CITY OF ALBUQUERQUE

**Planning Department
Transportation Development Services Section**

Re: Certification Submittal for Final Building Certificate of Occupancy for
Rex Lewis Storage Building, [K-21 / D032]
236 Muriel NE
Architect's Stamp Dated 06/24/08

Re: Traffic Circulation Layout (TCL) Submittal for Building Permit Approval for
Offices and Warehouse for Rex Lewis Storage Building [K-21/D-32]
(236 Muriel NE), Albuquerque, NM
Engineer's/Architect's Stamp Dated 09-20-2006

TRAFFIC CIRCULATION LAYOUT APPROVED

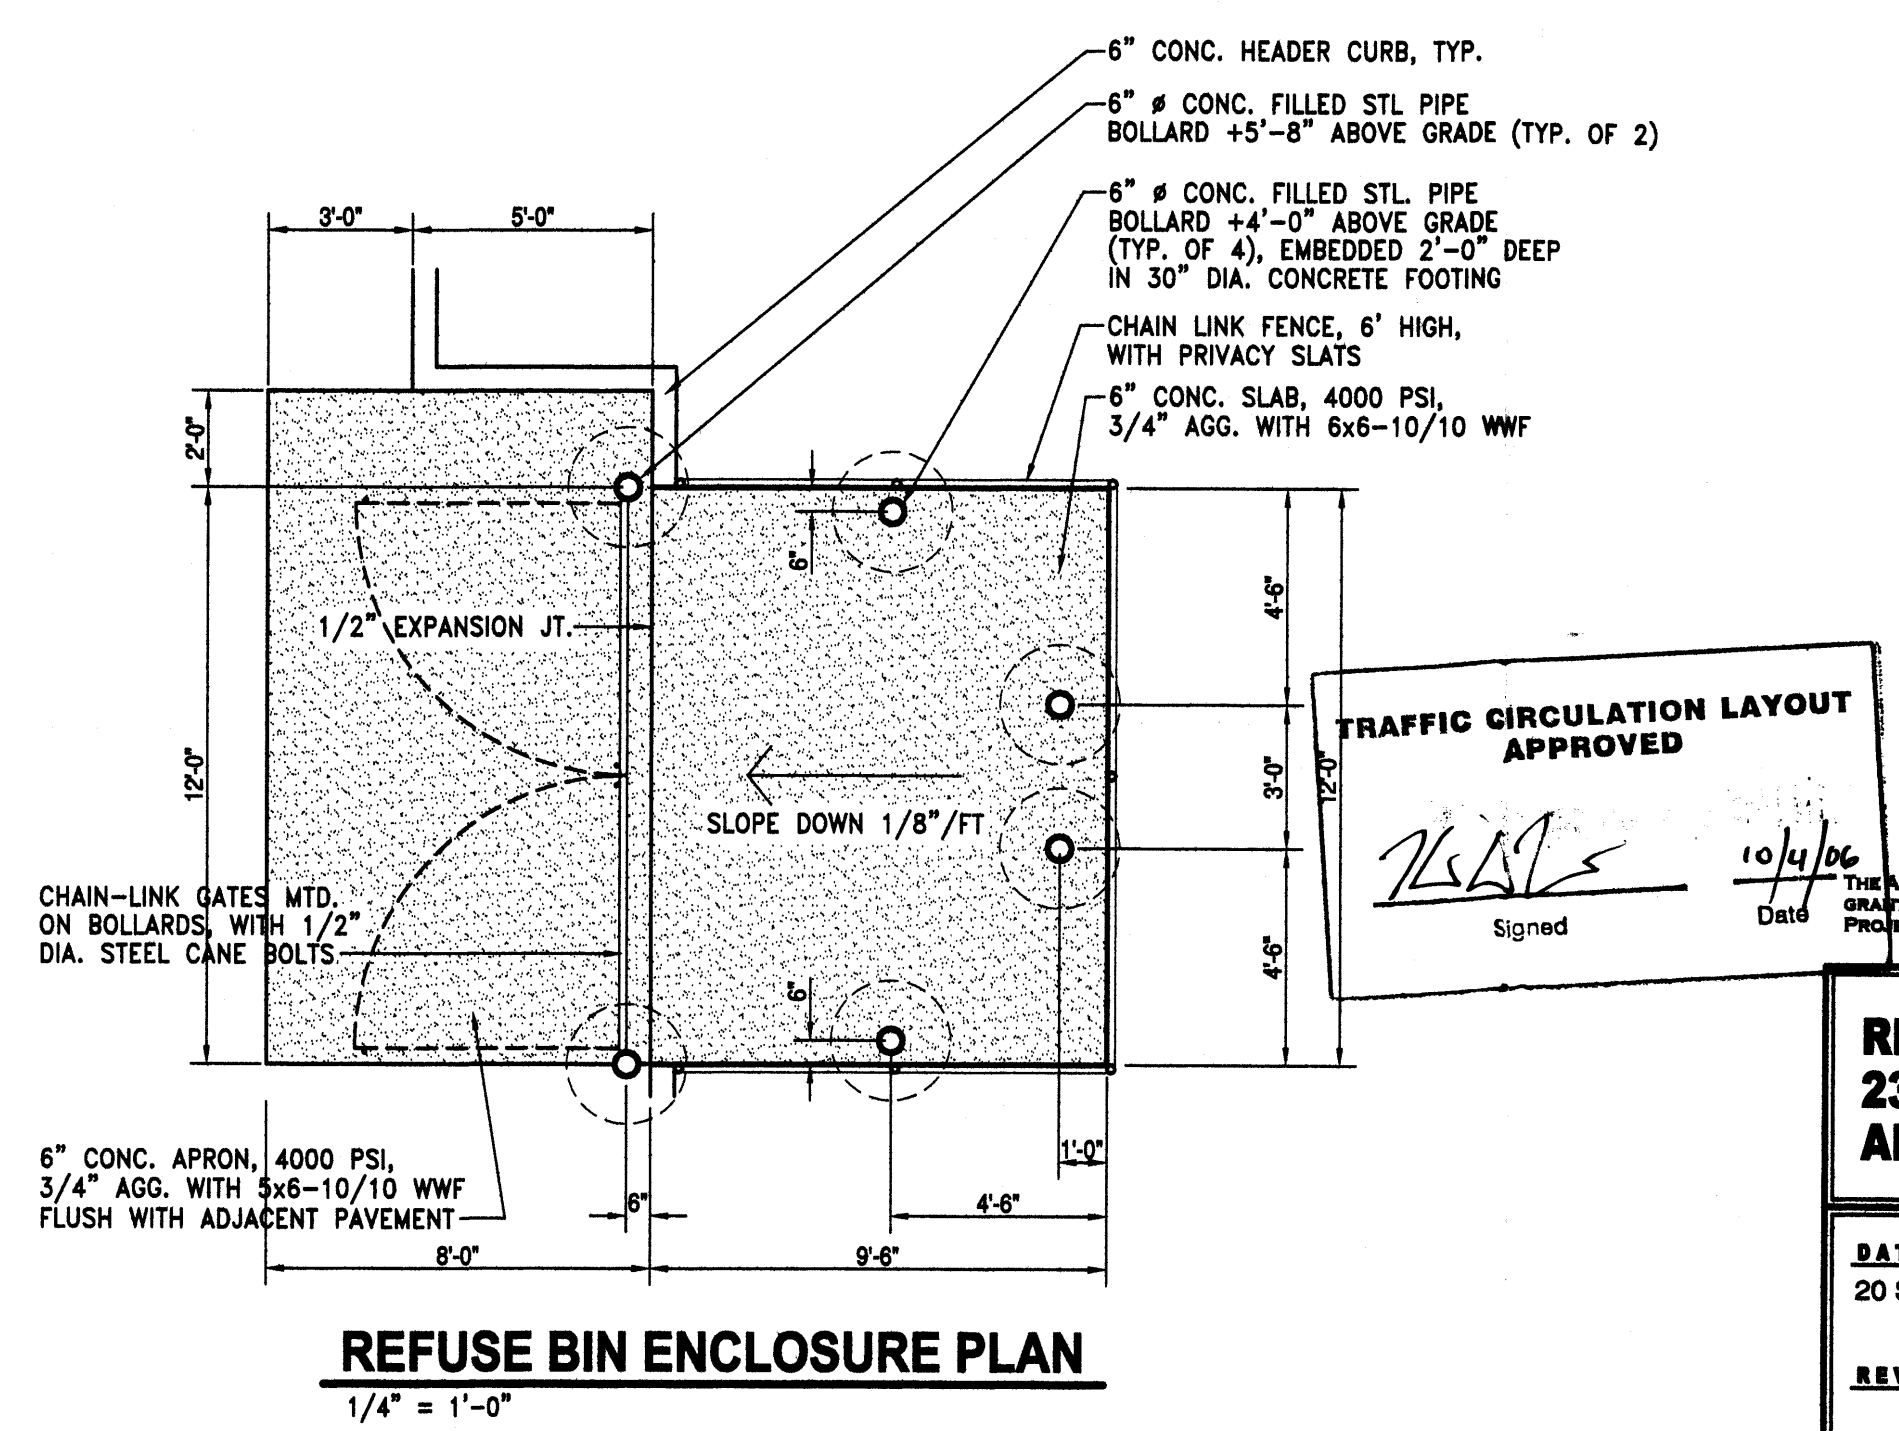
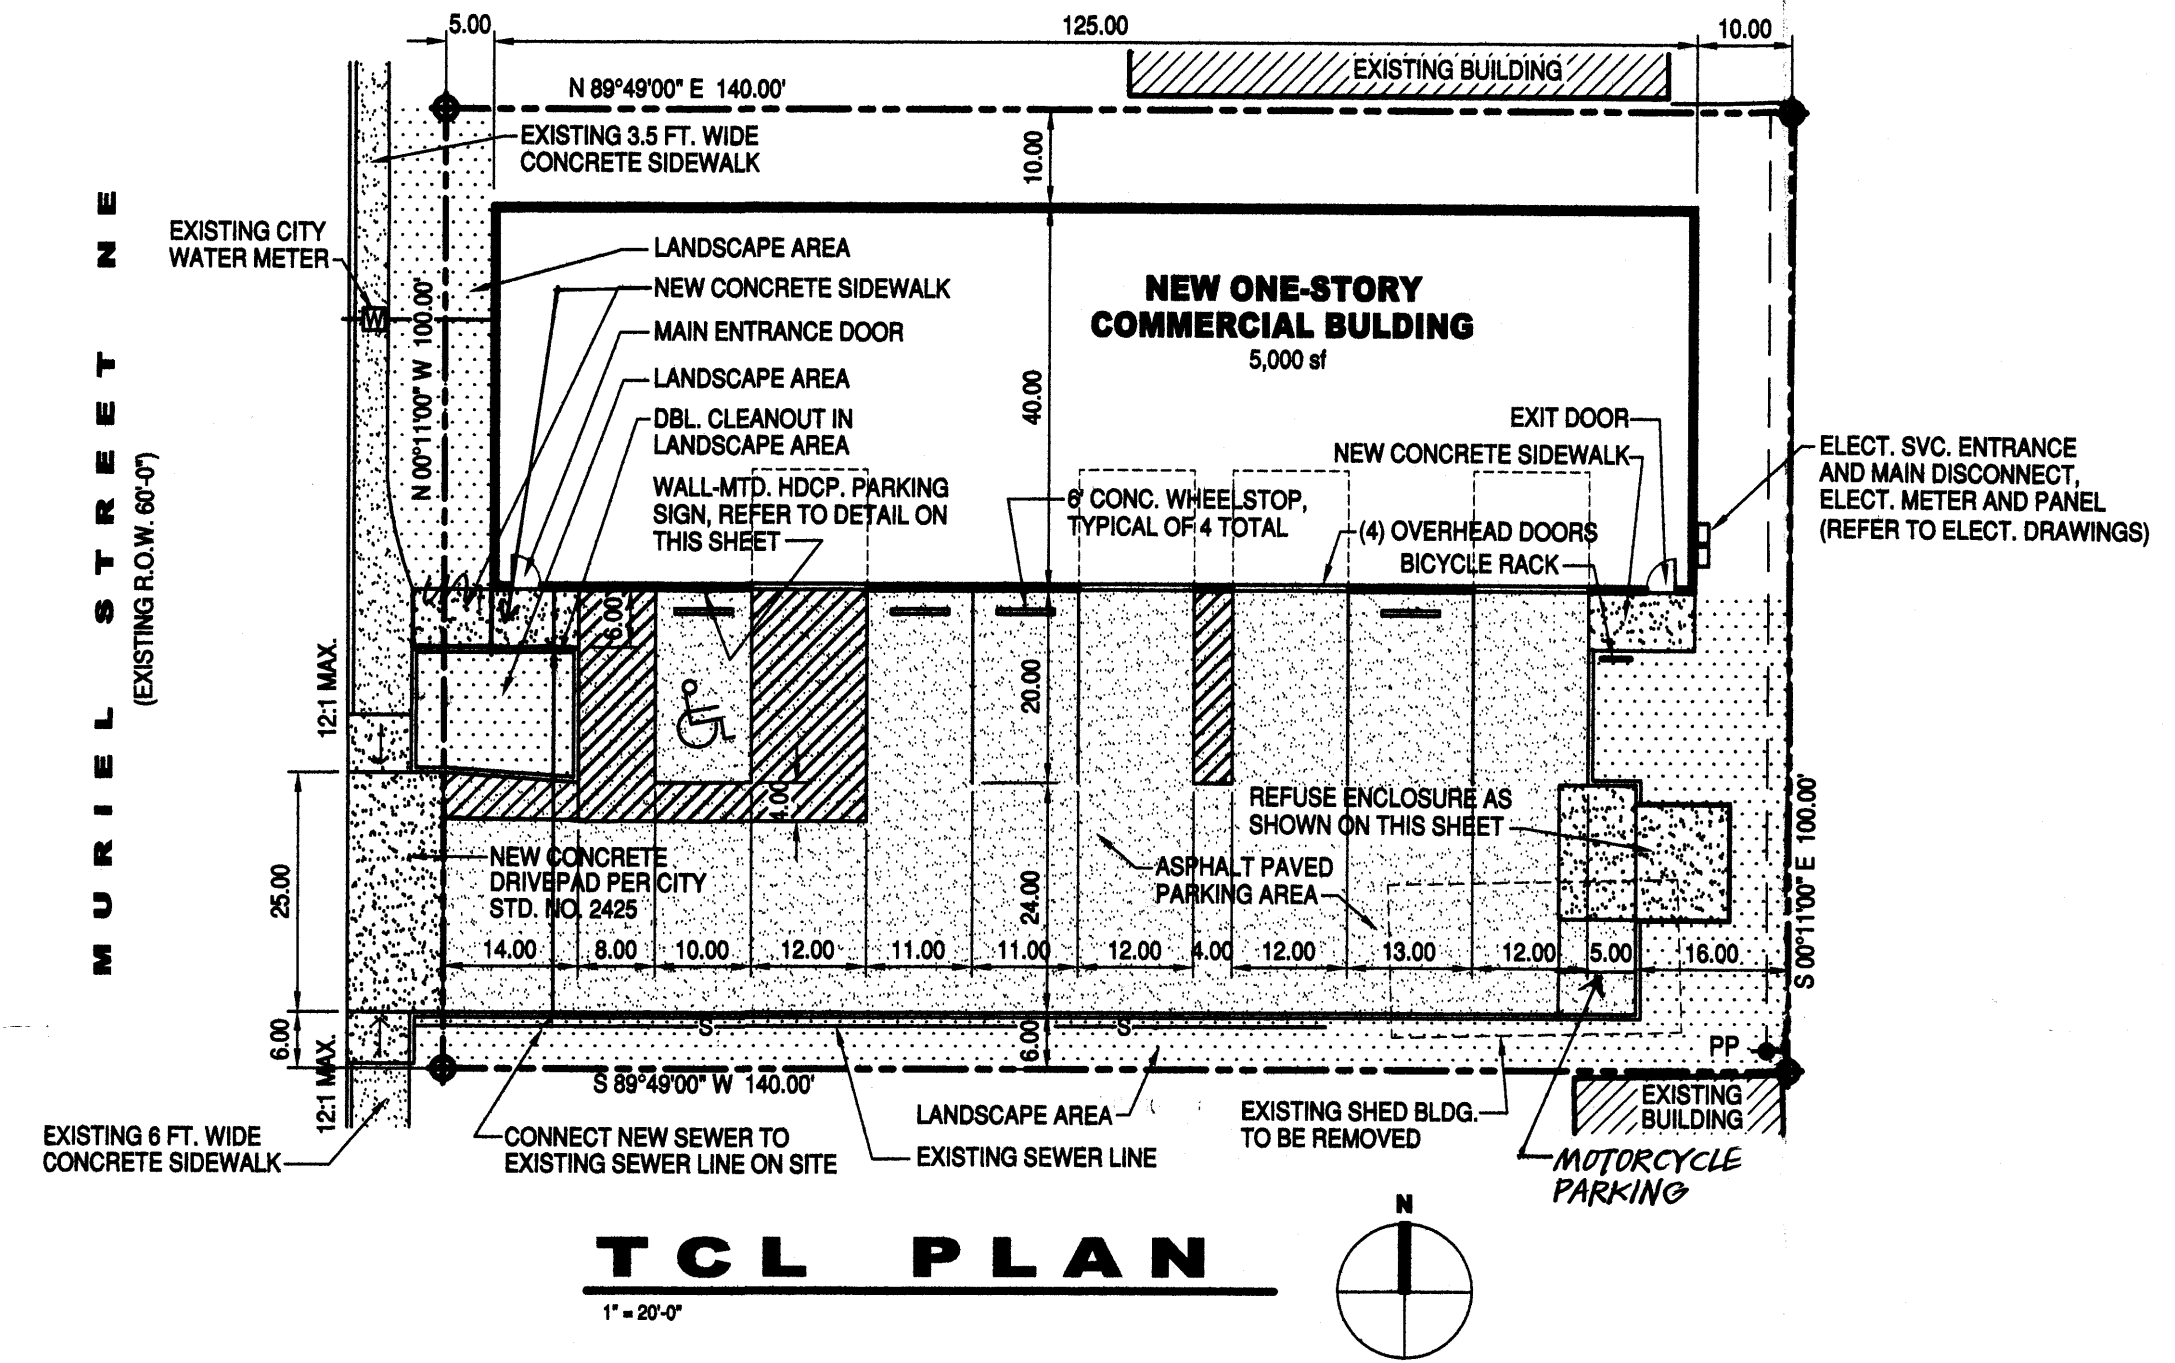
- ~~SW~~ North of Drive PAD
- ENSURE Drive pad conforms to 3' @ 2% cross slope
move ADA ACCESS to ~~BACK~~ of property LINE
- Move SIDEWALKS to property LINE
- ~~Accession~~
- PLAN NEEDS TO BE 24" x 36"
- ADA PARKING

Extents of sidewalk replacement req'd

Must have the 3', 2%
cross access across
the drive pad

How will the 3', 2%
path work w/ this?

Can the wheelchair path enter the driving area?

Aisle cannot be part of driving aisle
- move the door?
